**SUBMISSION TO THE DEPARTMENT OF PLANNING AND INFRASTRUCTURE ON THE PROPOSED
NORTH WEST RAIL LINK (NWRL)**

Application Number: **SSI-5100**

Whilst I support in principle the construction of the NWRL to provide much needed public transport to the rapidly growing housing areas of north west Sydney and to reduce the pollution and congestion associated with road transport, I object to the following regarding the Cheltenham Intermediate Services Facility.

Figure 6.11 Cheltenham Services Facility light vehicle access and egress

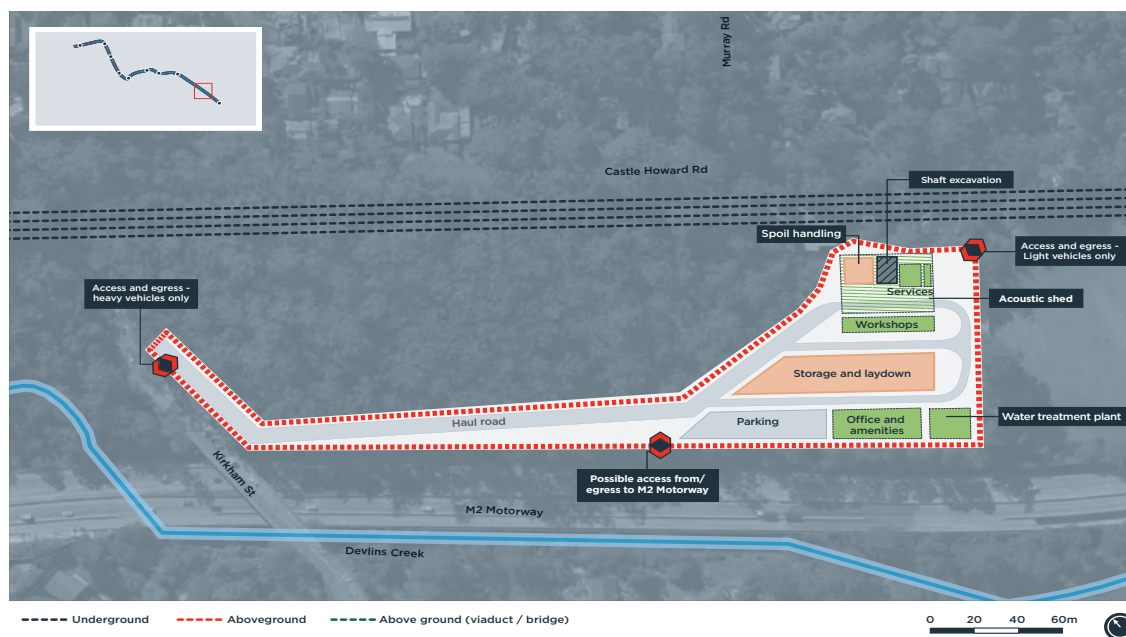
1. The option to construct a new two lane paved road through the Castle Howard Conservation Reserve to Kirkham Street (or Castle Howard Road) near the bridge over the M2 to allow trucks to remove spoil during construction and light vehicle access during operation of the facility will permanently destroy valuable Blackbutt Gully forest.

5. Should the roadway be built, the local streets (Kirkham Street, Castle Howard Road, Murray Farm Road and the bridge over the M2) are narrow, winding and congested and would not be suitable for trucks and, in the event of an emergency, large numbers of emergency vehicles.

6. There are no traffic lights at the corner of Kirkham Street and Beecroft Road. This is a dangerous intersection for traffic and pedestrians and would not be suitable for trucks and emergency vehicles.

I therefore ask that you adopt the alternative option of access to the site for construction and emergency vehicles be via new on and off ramps from the M2 motorway. The current widening and reinstatement of the breakdown lane should allow this access. It is the only practical way to move trucks in and out of the site. In the event of an emergency, many emergency vehicles would need quick access to the site from areas outside Beecroft and Cheltenham as it only has one fire engine.
